ITEM 1.9

Issue/ Objection:  
Crime Prevention  
Assessment

REVISION	DATE	DESCRIPTION	BY
			<b>SYDNEY</b> Level 5, 70 King Street Sydney NSW 2000 Australia T +61 2 9251 7077 F +61 2 9251 7072 E fjmt@fjmt.com.au W www.fjmt.com.au
NOMINATED ARCHITECT: RICHARD FRANCIS-JONES (REG NO 5301)			
PROJECT			
85 Harrington Street The Rocks GOLDEN AGE & HANNAS THE ROCKS			
TITLE			
RESPONSE TO DoPE ITEM 1.9			
SCALE	1:200 @ A2	PROJECT CODE	
DATE	18/10/2017	GA85H	
SHEET NO.	024	REVISION

4 PLAN Level 2
1:500

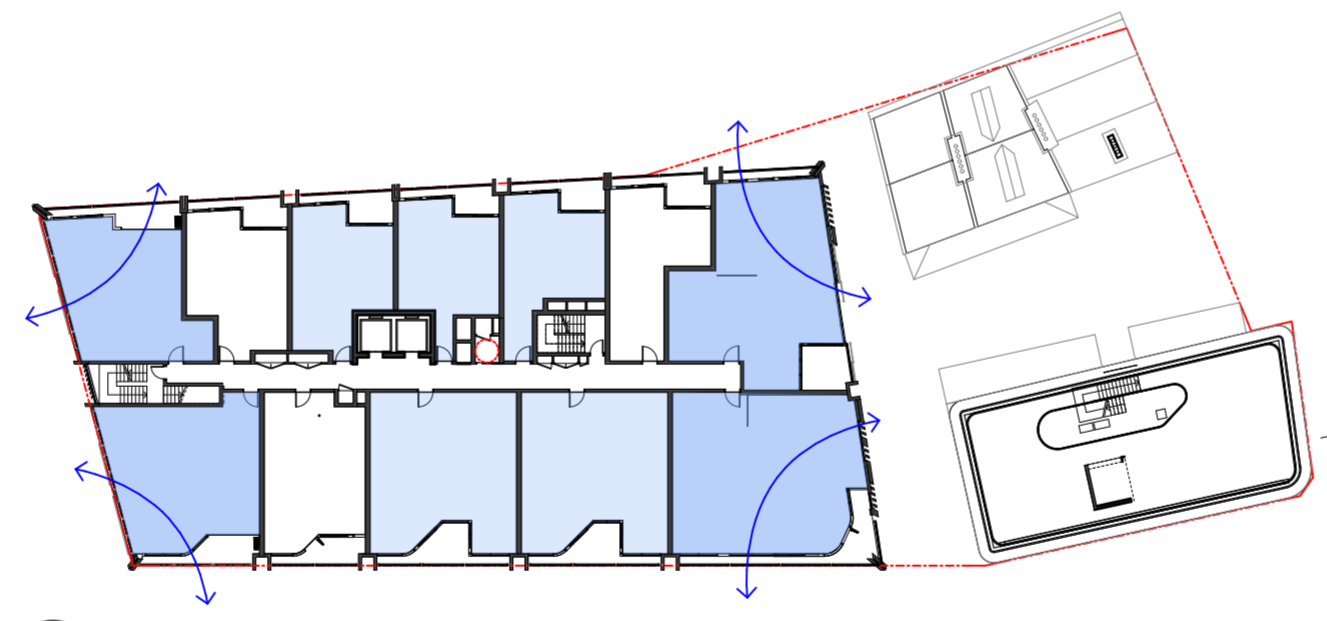
Description:  
Please provide evidence of measures taken in preventing crime around  
Level 2 public lift, lift access ramp and to the adjacent apartments.

- Restriction of lift access at 10pm
- Provision of a gate on Gloucester Street at the public entry of the lift access ramp
- Gate is accessed controlled with residential over-ride to allow residents in Baker's Terraces to access basement carpark
- Both the gate access and lift access restrictions are operated by building management

- CCTV in locations indicated, feeding to 24/7 building management

- Passive surveillance from adjacent through-site link and public open space

- Additional passive surveillance from Baker's Terrace balconies and Unit 312 Gloucester Street entry

- Adjacent apartments 201 and 312 achieve acoustic privacy through the utility of double glazing to its windows interfacing with the public ramp.

- Wayfinding signage will be provided indicating that the area is under surveillance
